**KIRKLEES METROPOLITAN COUNCIL  
INVESTMENT & REGENERATION SERVICE**

**DELEGATED DECISION TO DETERMINE PLANNING APPLICATIONS**

Reference No:	<b>2025/62/92993/E</b>
Site Address:	rear of, 9, Riley Lane, Kirkburton, Huddersfield, HD8 0RZ
Description:	Erection of detached dwelling with integral garage
Recommending Officer:	Elenya Jackson

**DECISION – REFUSED**

DRAWING TITLE  
**PROPOSED SITE SECTIONS**

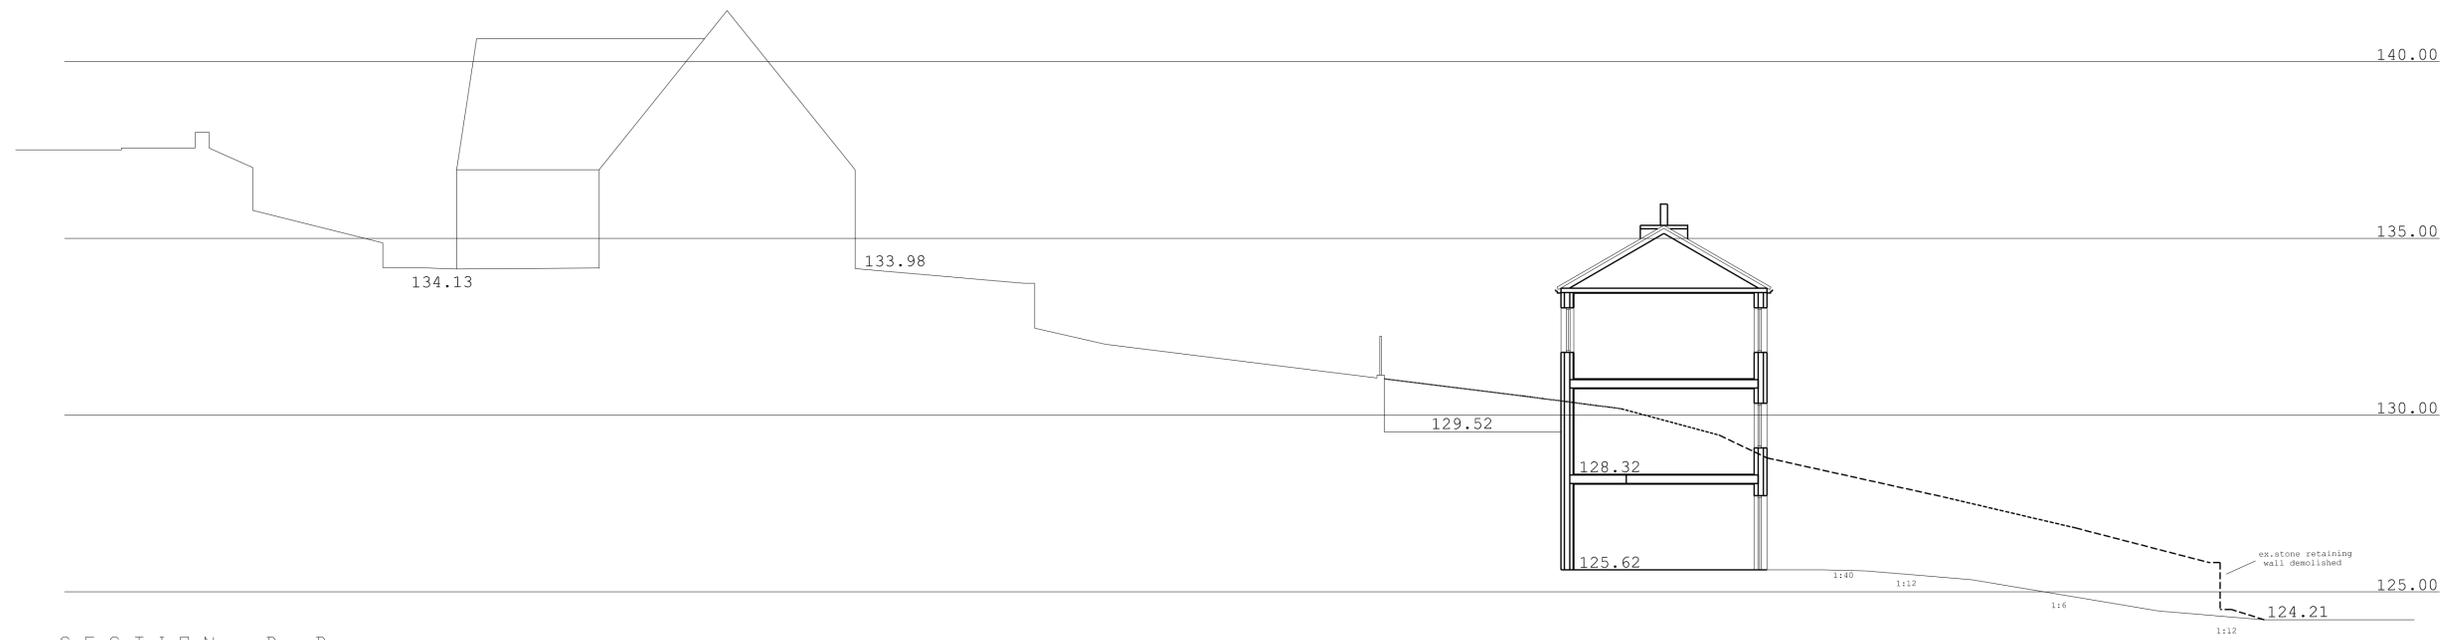
KC Highway structures have requested clarification on if the retaining wall would be reduced to 1m to accommodate the required visibility splays on site, in which case a “before” and “after” dilapidation condition survey of the existing dry stone wall by a suitably qualified and experienced engineer and moreover, will be required to rectify any damage to the wall attributable the development at their cost. Or if the applicant intends on removing the existing dry stone retaining wall down to its footing and replace it with a new wall with a retained height not exceeding 1.0m, a suitably scaled and dimensioned X-sectional detail would need to be provided to support the application.
